Planning Application Ref: BN/139/20/PL

Location: The Cottage, Highground Lane, Barnham, PO22 0BT

Description of works: 1no dwelling. This application is a Departure from the Development Plan & is in CIL Zone 3 and is CIL Liable as new dwelling

SITE / BLOCK PLAN 1:500

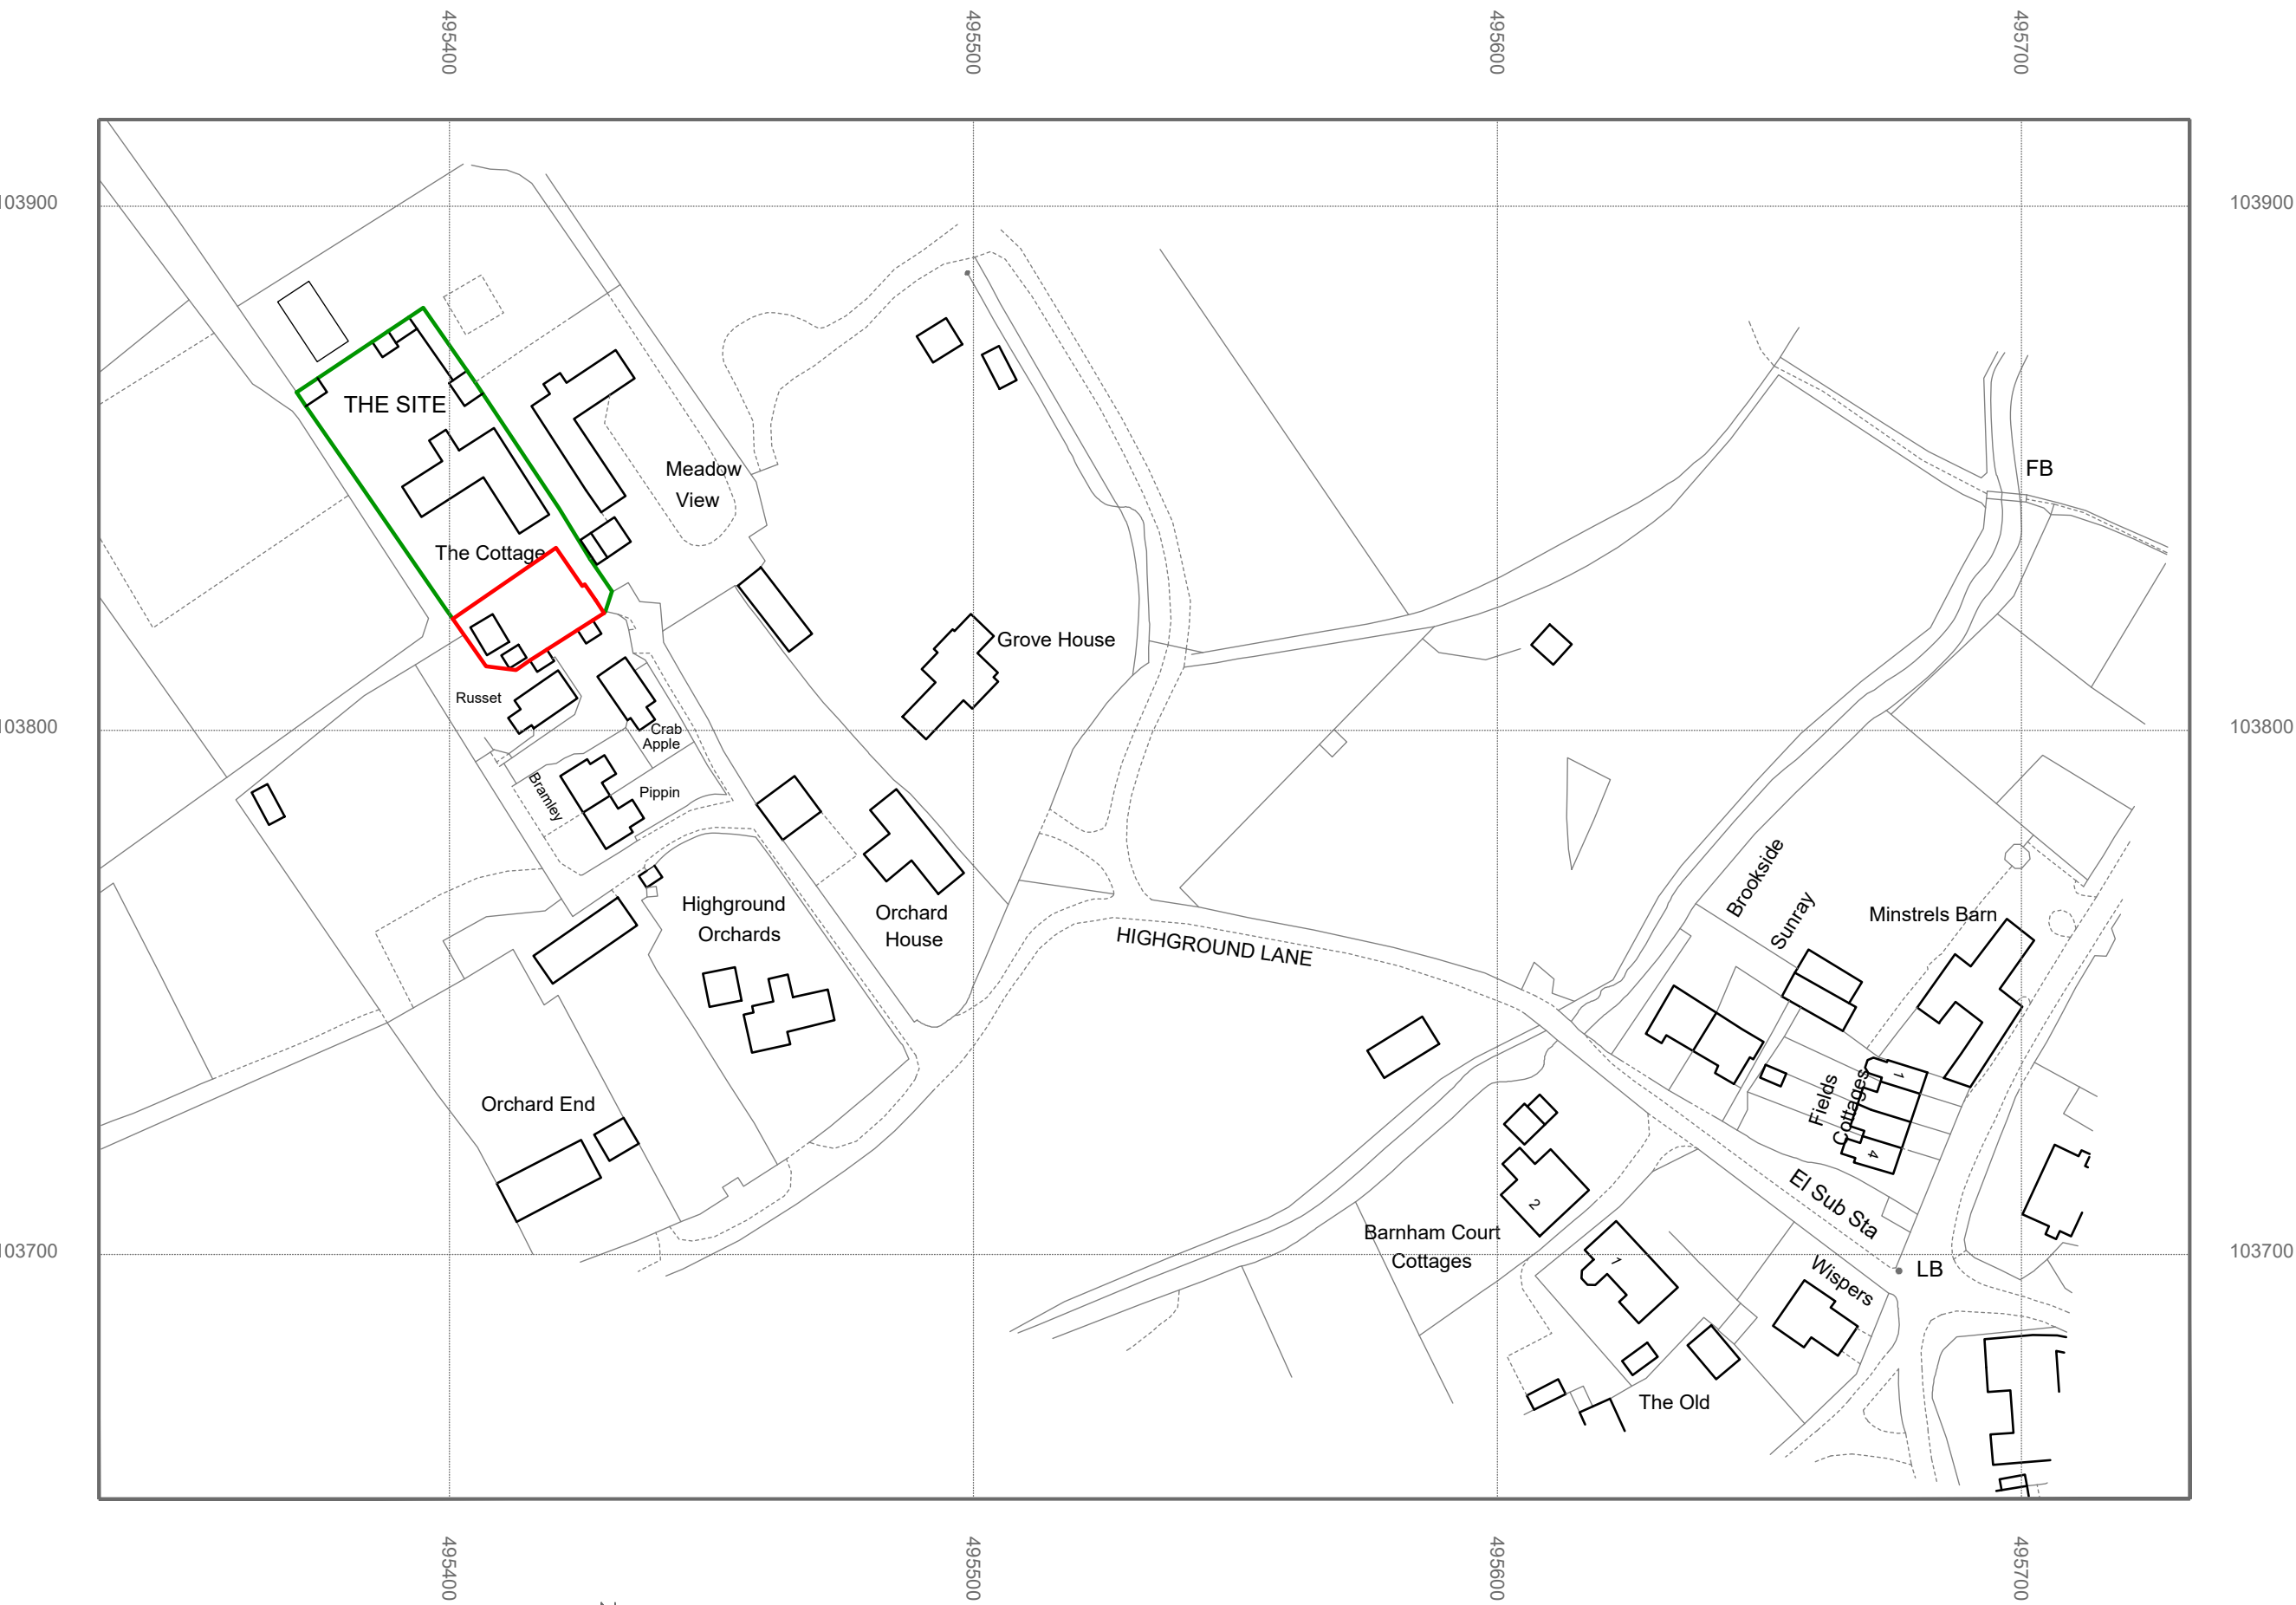
- I have considered this application by means of a desktop review, using the information and plans submitted as well as online resources.
- It has been stated within both the Design and Access Statement and Application form (sect.10) that an Arboricultural Report is unnecessary, as there are no trees or hedges on the proposed development site, nor on land adjacent to the proposed development site that could influence the development or might be important as part of the local landscape character. It is clear that at least the former statement is incorrect, and both may be so.

- Those established trees are likely to be adversely affected or destroyed to facilitate the proposal. There is no supporting arboricultural information submitted with the application - a requirement of BS5837:2012. As such, were this application to now proceed, we will not have sufficient information to guarantee such trees would be adequately considered and protected.

1. The applicants will need to employ the services of an Arboricultural Consultant to carry out a tree survey exercise and then prepare an Arboricultural Impact Assessment (AIA) which must be inclusive of; a 'Tree Survey Schedule', a 'Root Protection Area (RPA) Schedule' and a 'Tree Constraints Plan' – with the trees accurately plotted on same.
2. In the event that a RPA of any tree which is proposed for retention overlaps the development then BS5837:2012 requires that the Detailed Planning Application is accompanied by an Arboricultural Method Statement (AMS) and also most importantly a Tree Protection Plan – to both describe and illustrate the mitigation measures which are to be employed to ensure that the trees survive without detriment to their vigour and vitality and are given adequate protection both above and below ground.
